Application No: FP/77/22/HH
Site Address: 27 Sea Drive Felpham PO22 7NE
Description of works: Garage conversion to habitable use and installation of 1 x side dormer.

OWPC47429

Drawing Name
Ground Floor, First Floor and Roof Plans -
Proposed

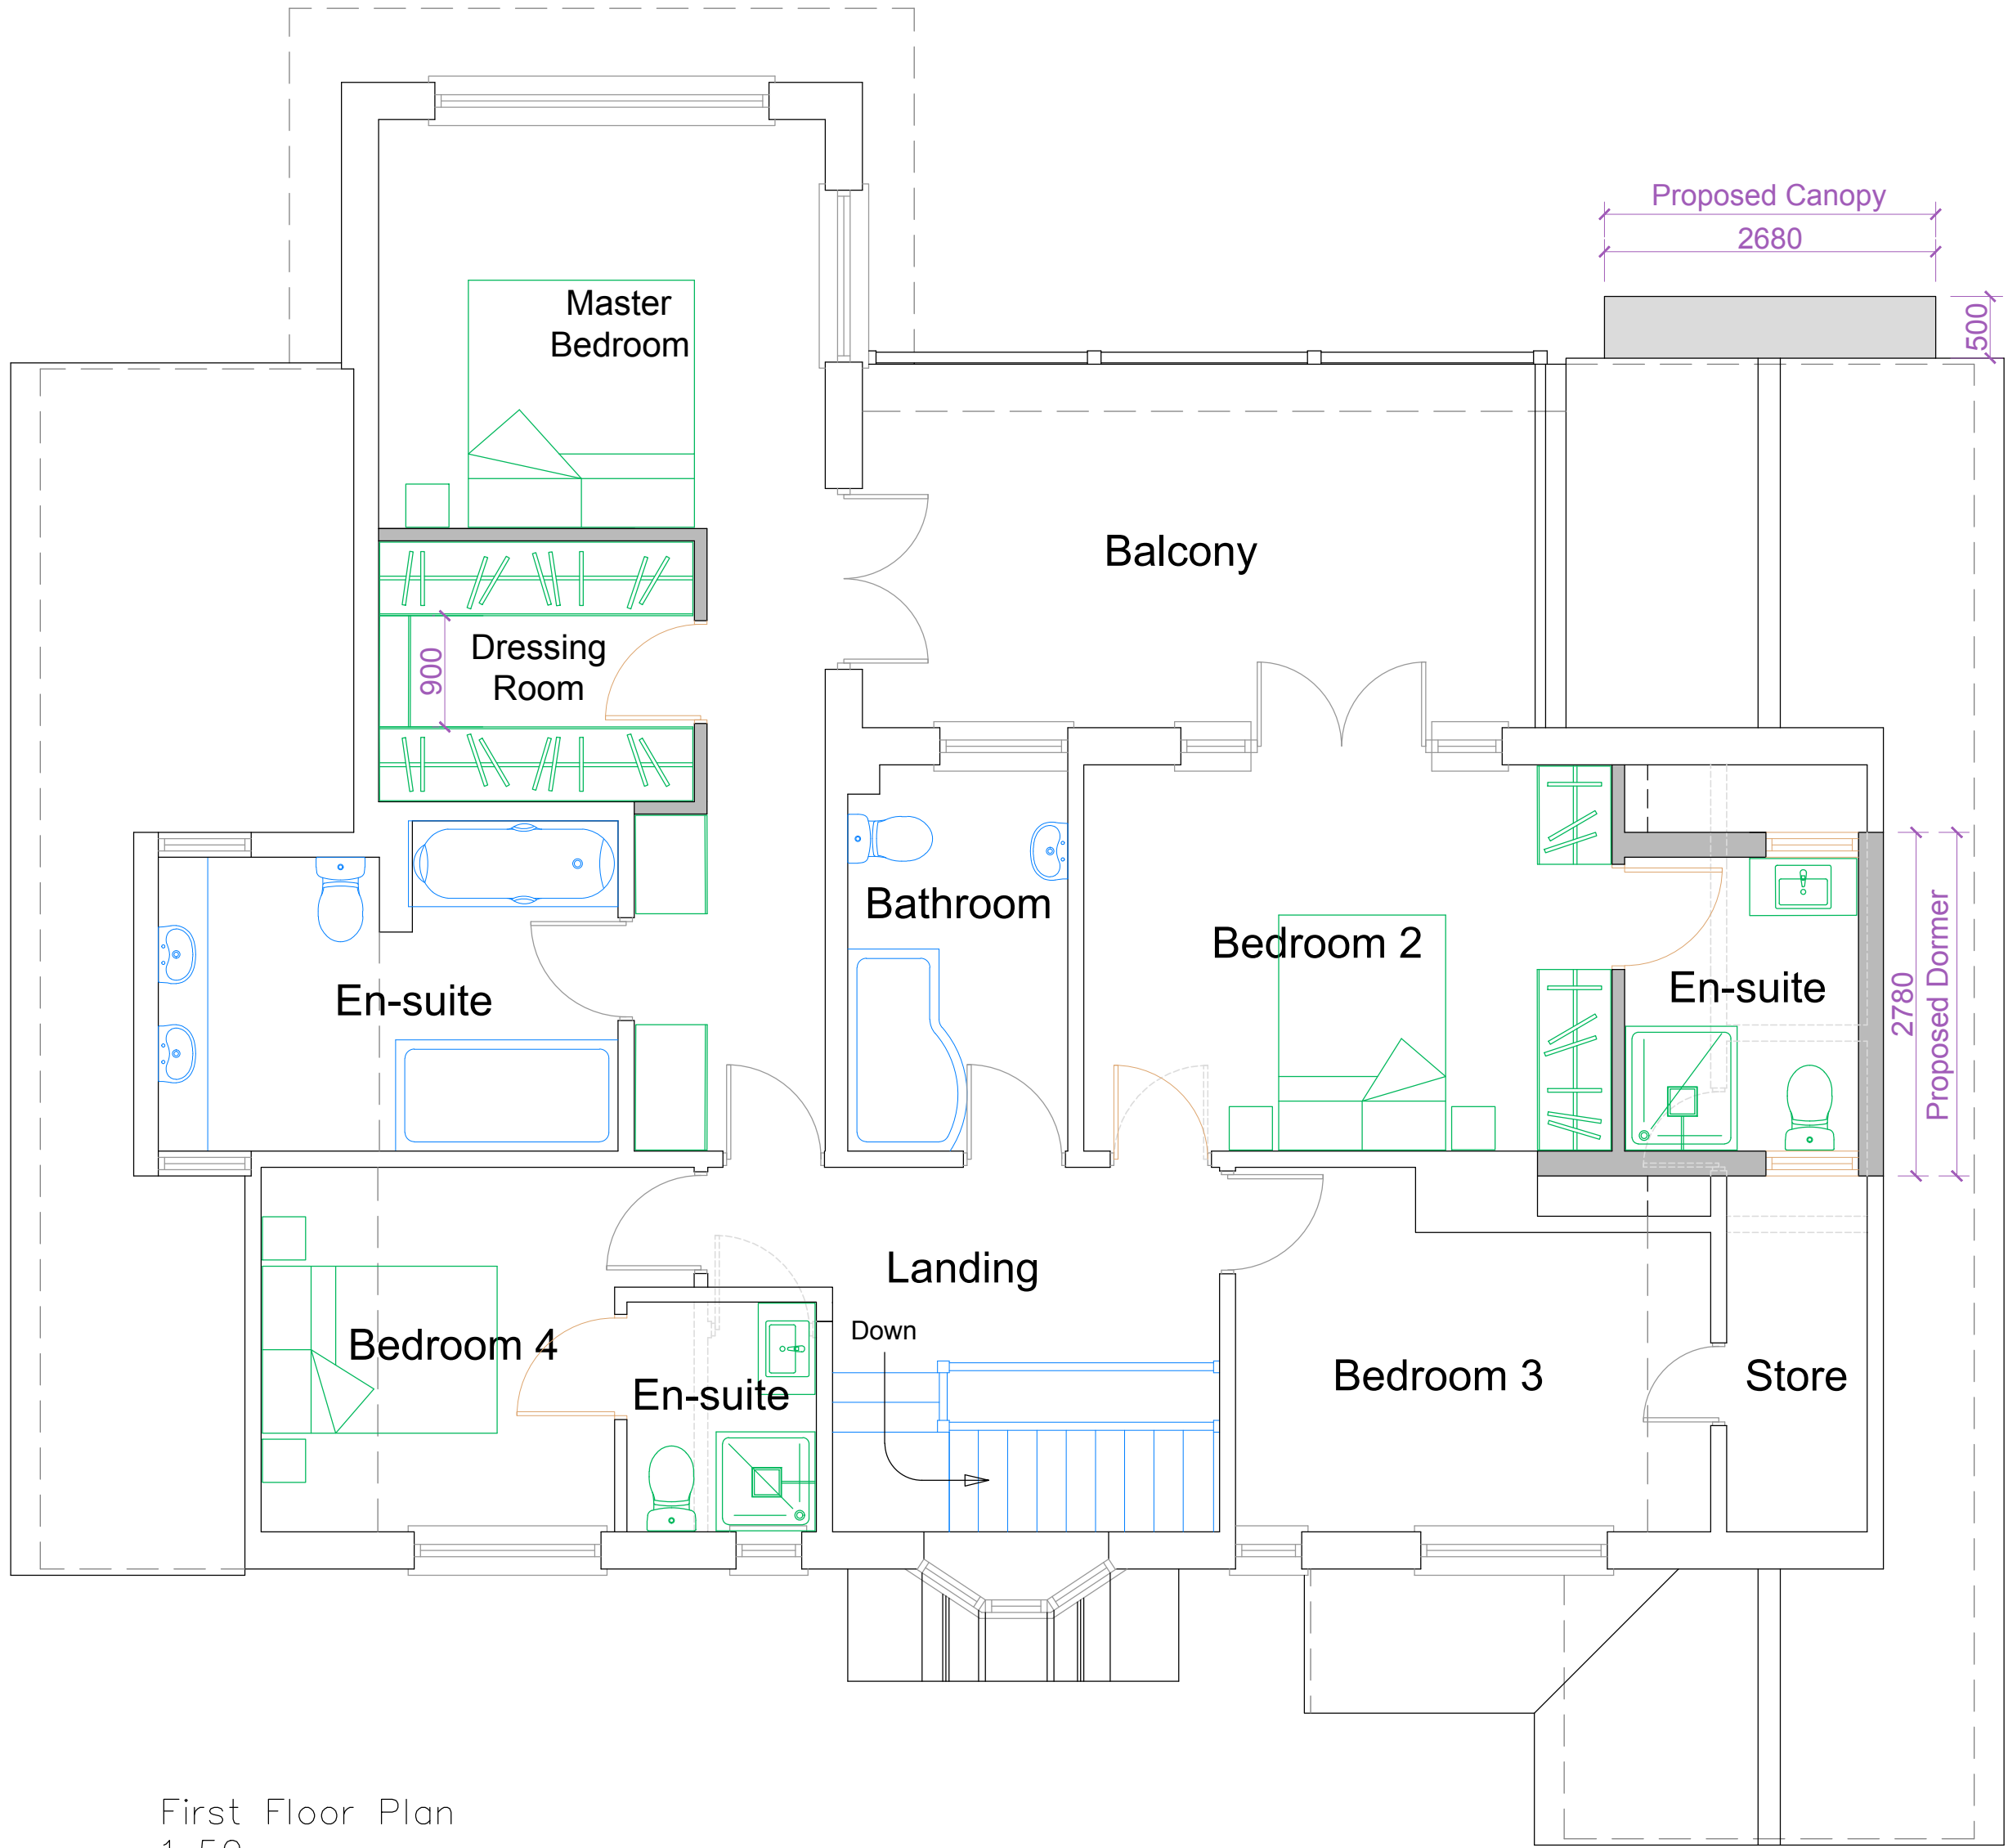
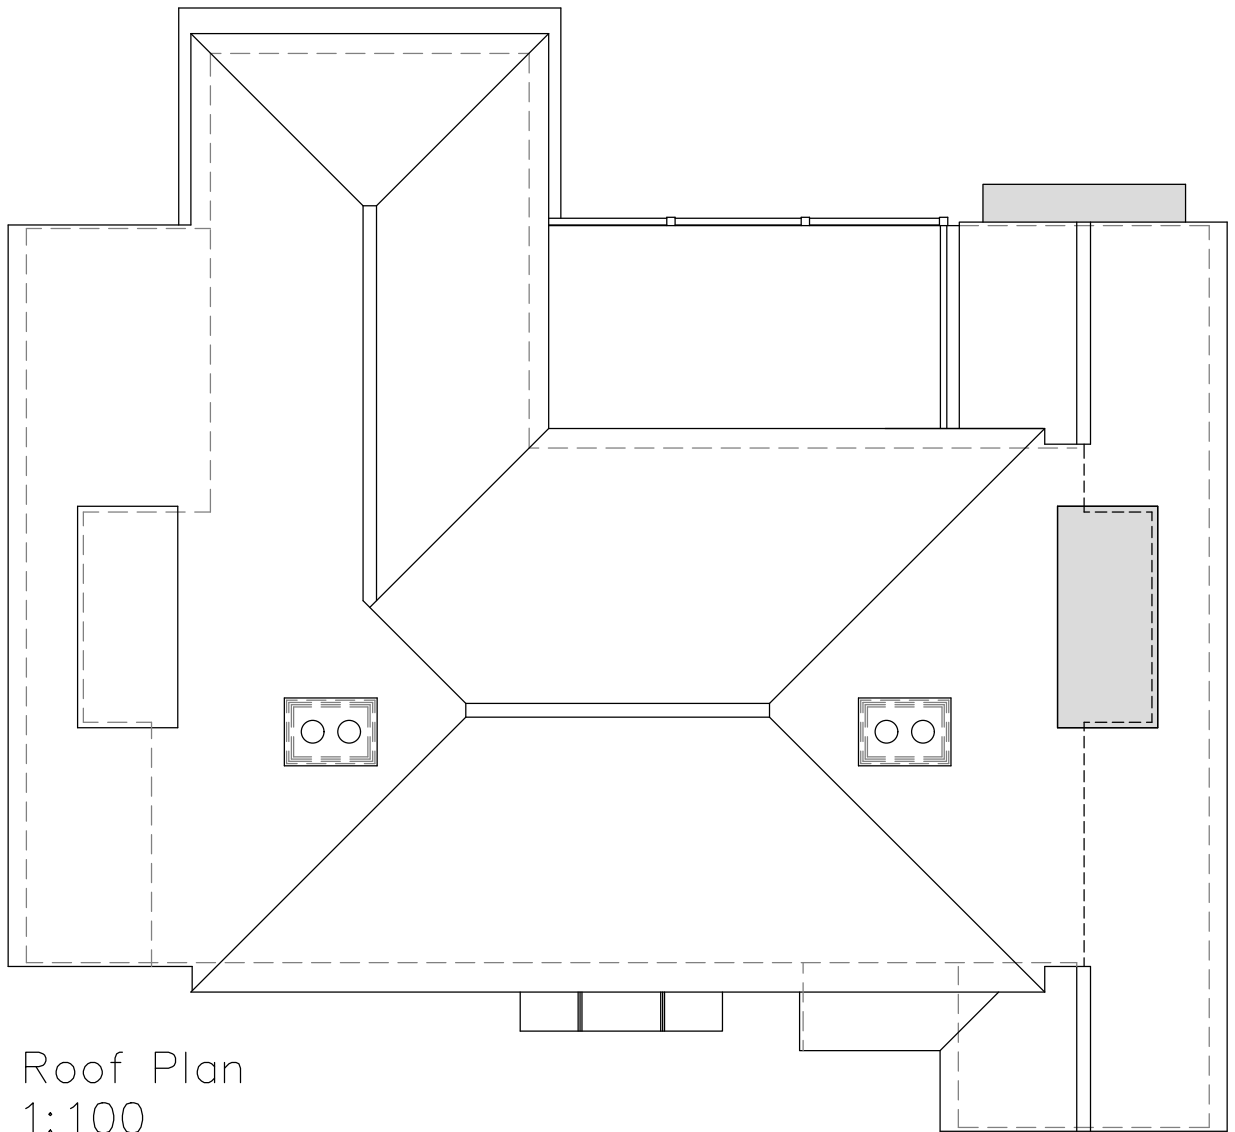
Felpham Parish Council have no objection to this application providing the dormer window has obscure glass fitted.
